MEMORANDUM

DATE: June 3, 2021

FROM: Jeff Rice, PCD-Engineering
719-520-7877

SUBJECT: PUDSP-21-006 – Ridge at Lorson Ranch (with EGP)
First Submittal

Exhibit 1
Deviation Request Location
Ridges at Lorson Ranch (LSC #S214080)

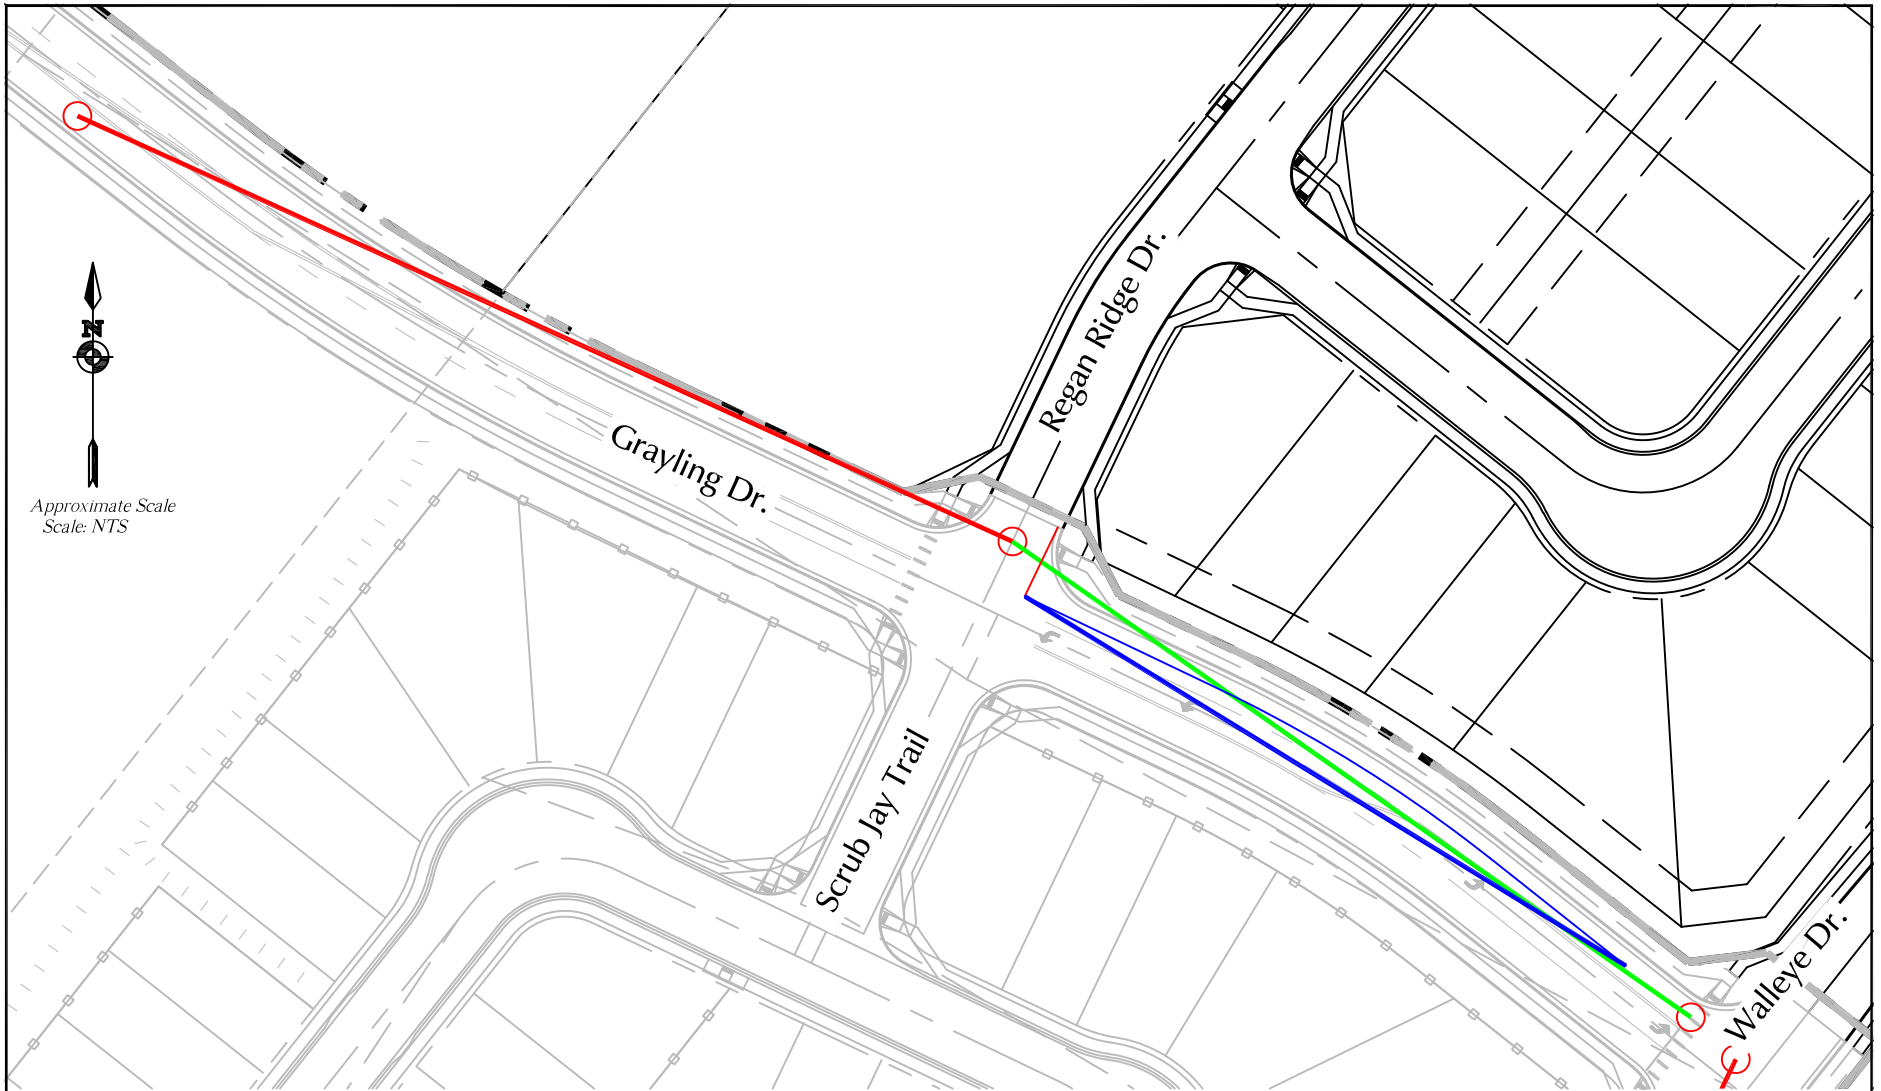
3. Provide deviation requests as applicable. If deviations are not approved, design revisions will be necessary.
LSC Response: Deviation requests will be submitted.
4. Note: The collector and arterial road improvements required by The Hills at Lorson Ranch (SF-21-010) need to be collateralized or completed prior to recording of a plat within the Ridge at Lorson Ranch PUDSP area.
LSC Response: Noted
5. See TIS redlines for additional comments.
LSC Response: See responses in redline document.
